CITY OF ALBUQUERQUE

May 12, 2010

Re: Question Construction Building, 2212 4th Street NW, Traffic Circulation Layout
Architect's Stamp dated 05-05-10 (H14-D103)

REVISIONS		
NO.	DATE	REMARKS
1	5.8.10	CITY OF ALB.
CAD DWG: JTK CHECKED: DPJ		
DWG. COMPLETE 100%		
SUBMITTAL PERMIT		
DATE 8 MAY 2010		
JOB NUMBER NM-09-052		
SCALE 1/8" = 1'-0"		
SHEET TITLE TRAFFIC CIRC.		
SHEET A1.1

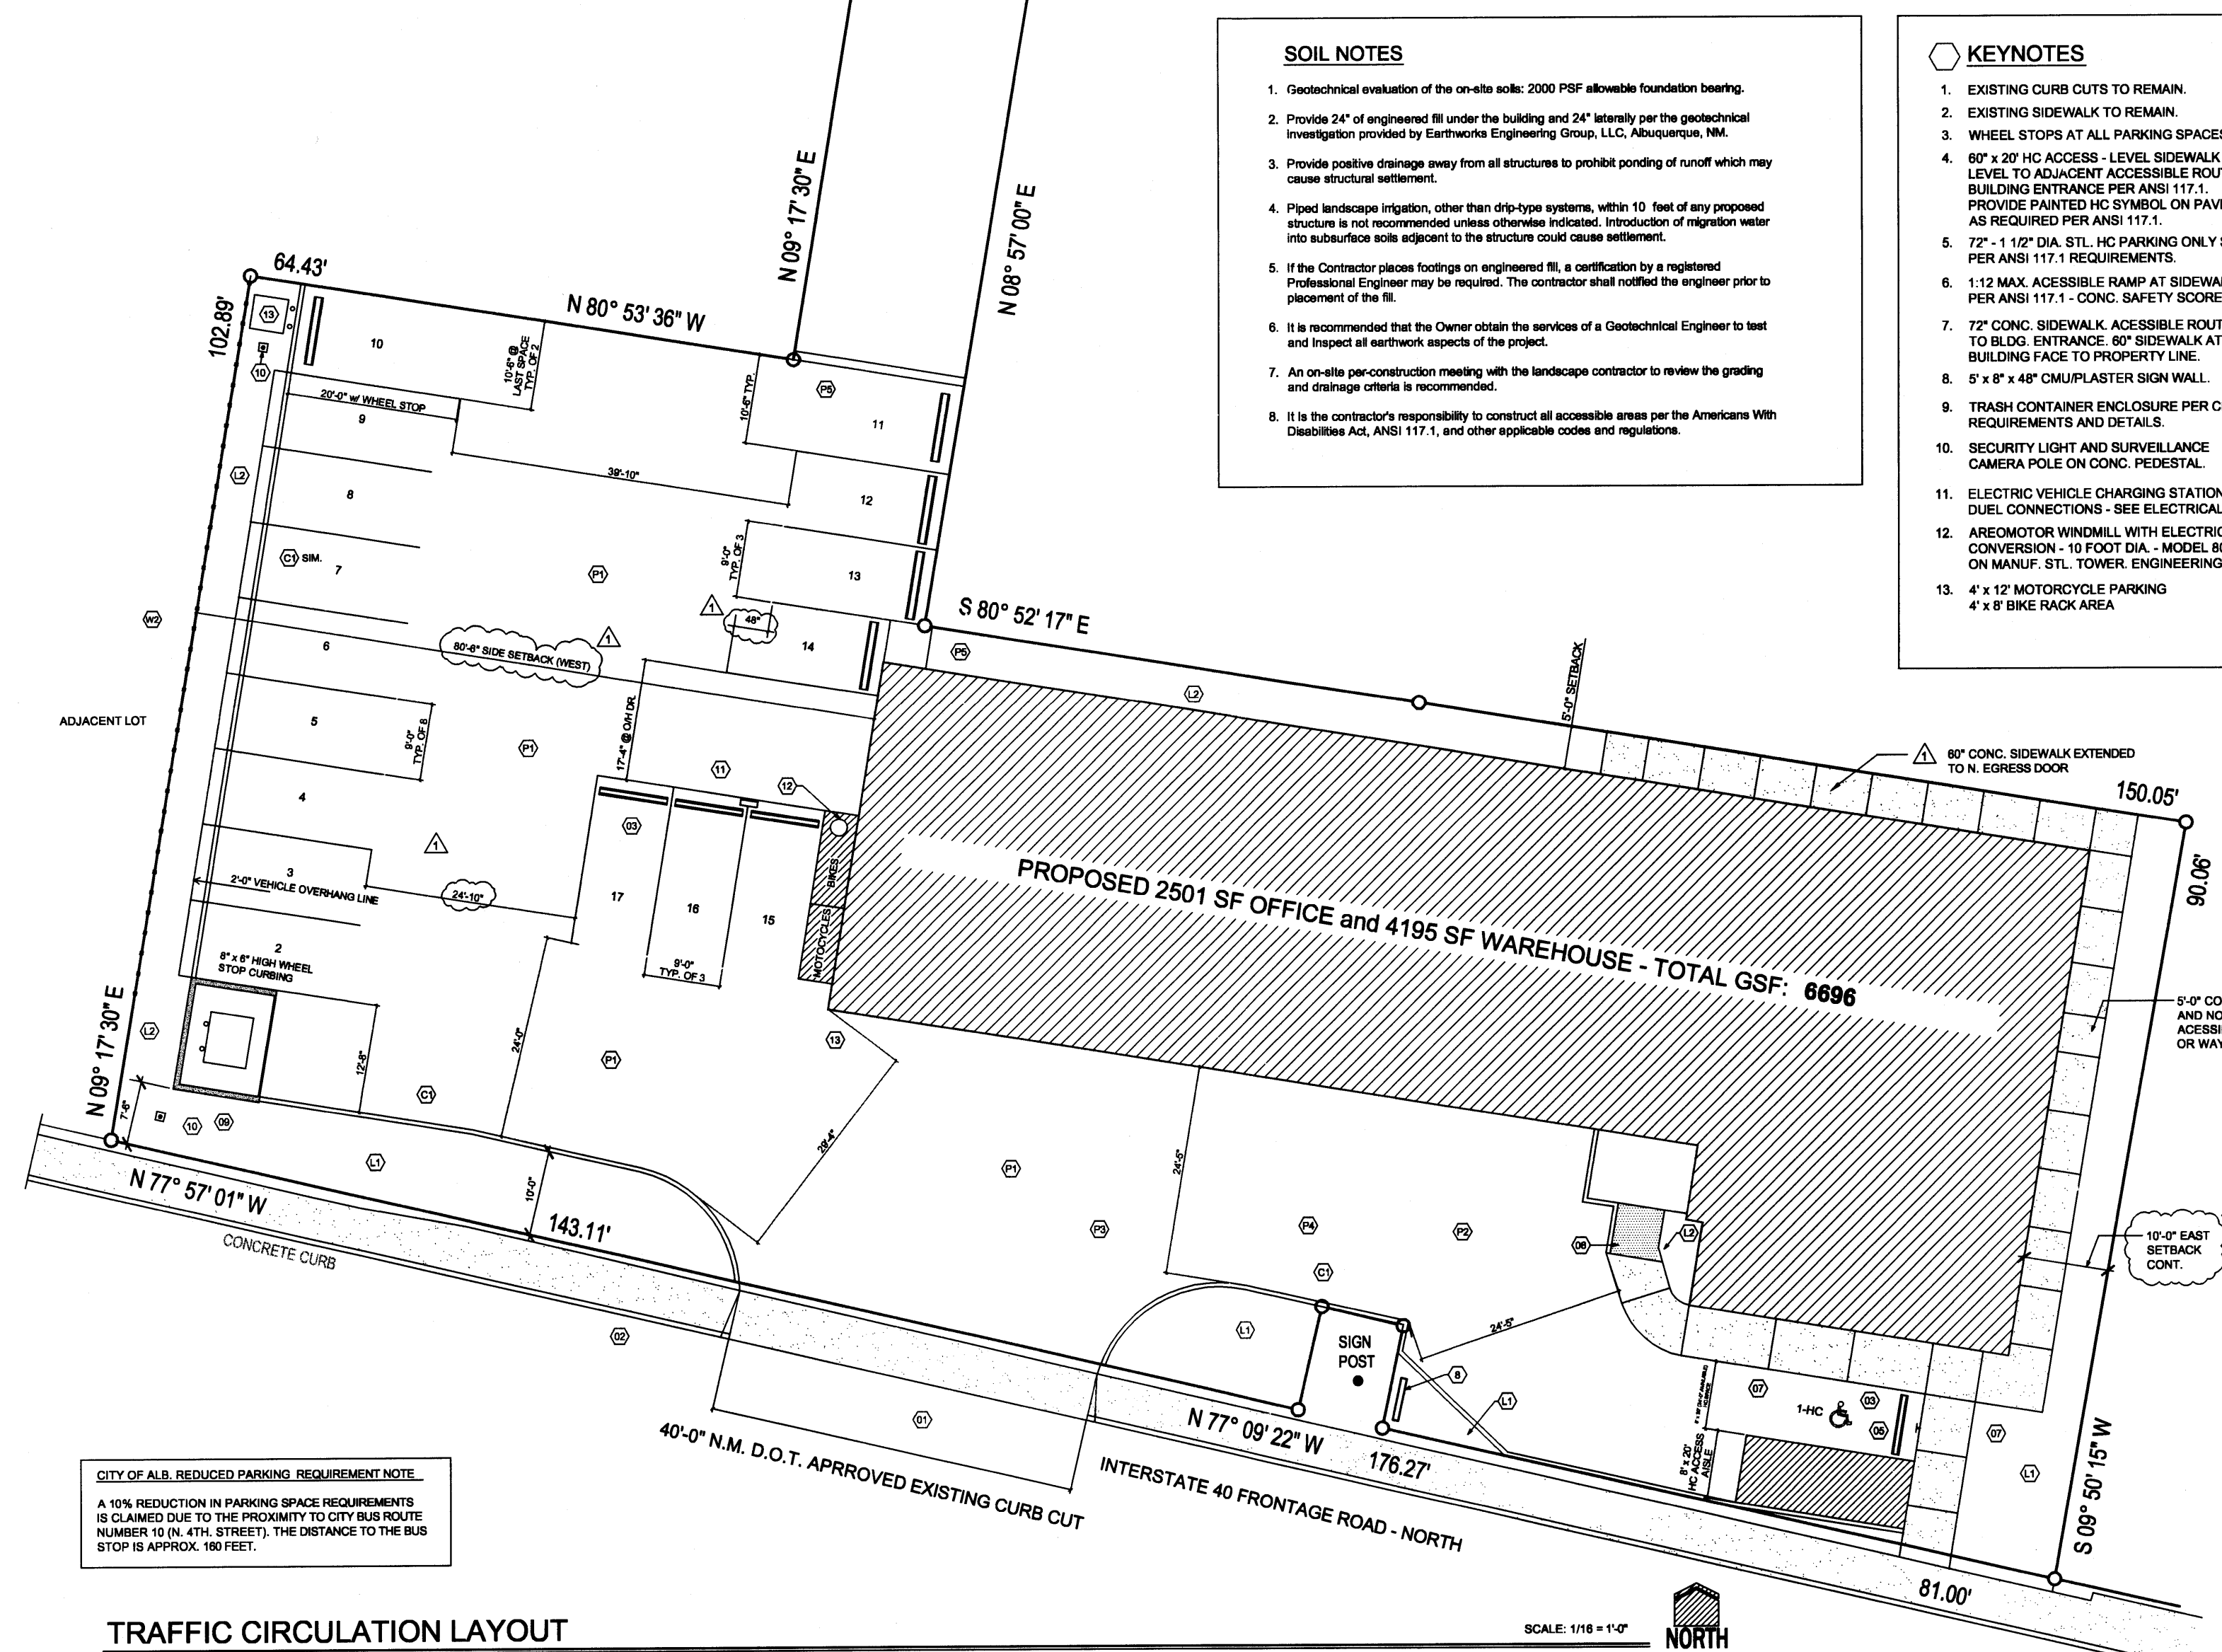
The TCL submittal received 05-11-10 is approved for Building Permit. The plan is stamped and signed as approved. A copy of this plan will be needed for each of the building permit plans. Please keep the original to be used for certification of the site for final C.O. for Transportation. **Public infrastructure or work done within City Right-of-Way shown on these plans is for information only and is not part of approval. A separate DRC and/or other appropriate permits are required to construct these items.**

GRADING & DRAINAGE PLAN

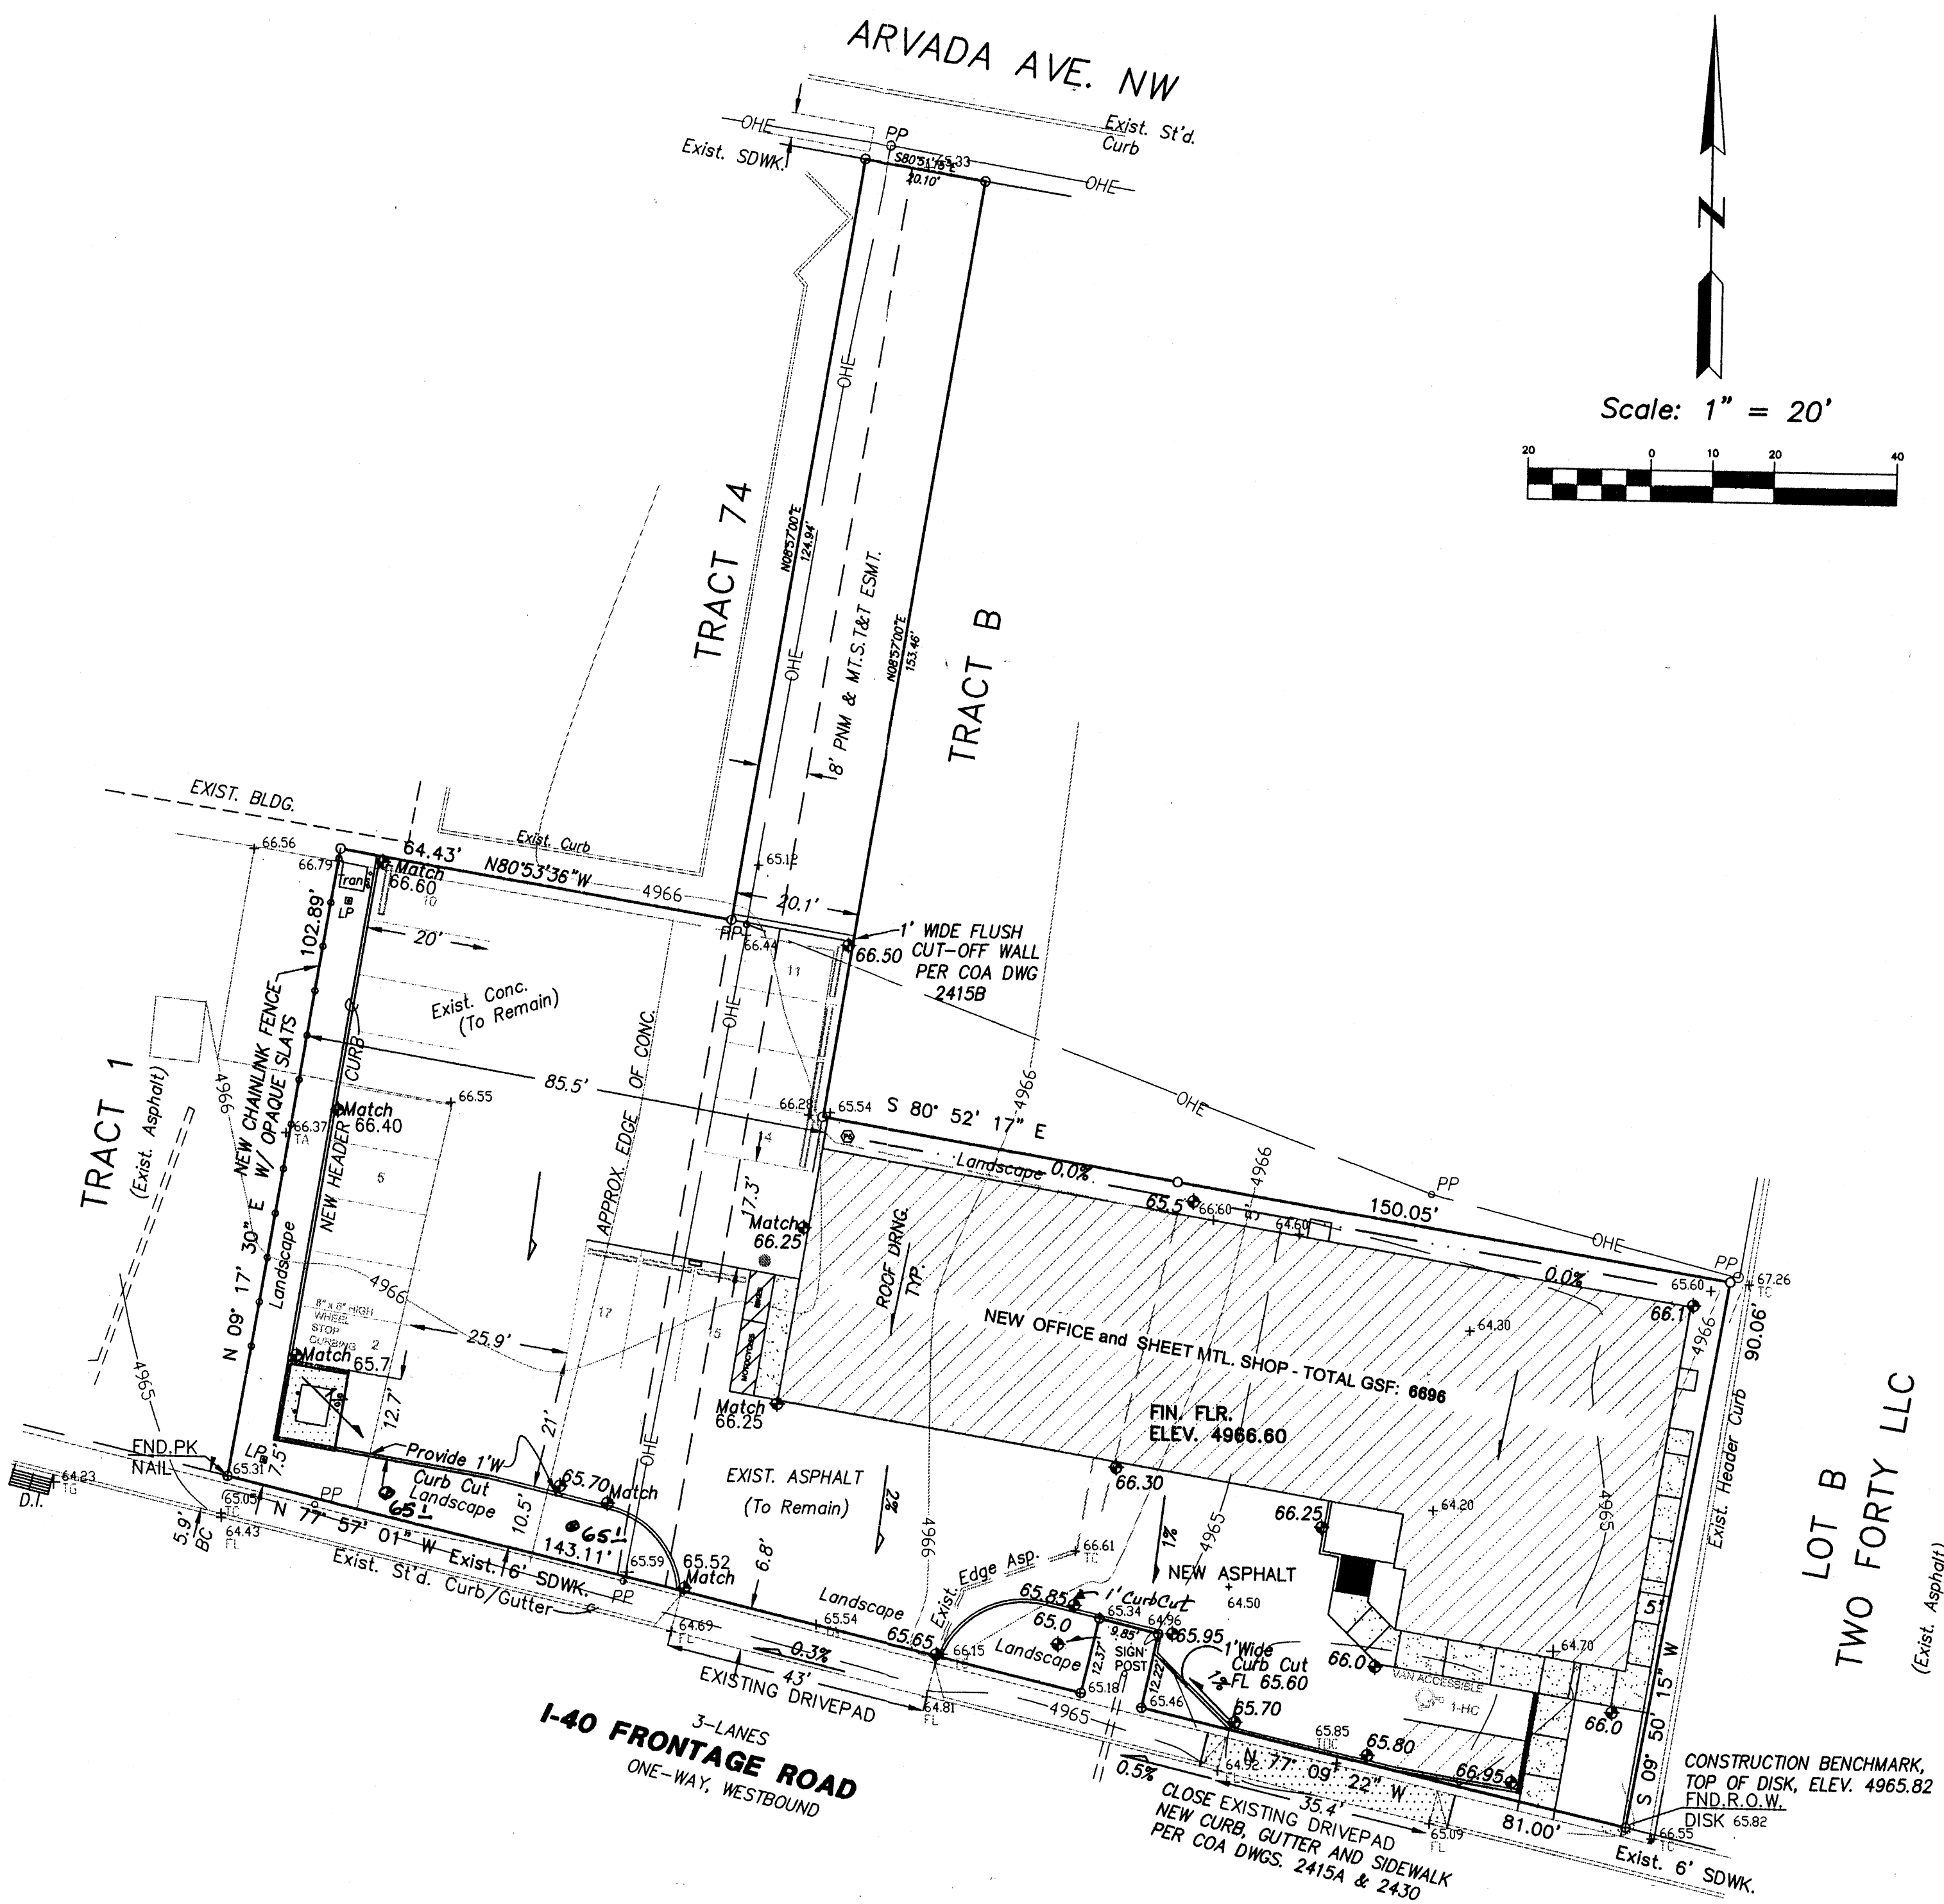
Based upon the information provided in your submittal received 9-15-09, the above referenced plan cannot be approved for Building Permit until the following comments are addressed:

- NMDOT approval is required. Provide correspondence.
- The lot to the north is flush or slightly lower than this site. Depress the landscape area north of the building or similar to prevent runoff from crossing the property line.
- The FIRM Map provided is too dark. This site has an AO zone on its south boundary. This should be discernable on the FIRM or discussed in the narrative.

Based upon the information provided in your submittal received 11-4-09, the above referenced plan is approved for Building Permit. Please attach a copy of this approved plan to the construction sets prior to sign-off by Hydrology.
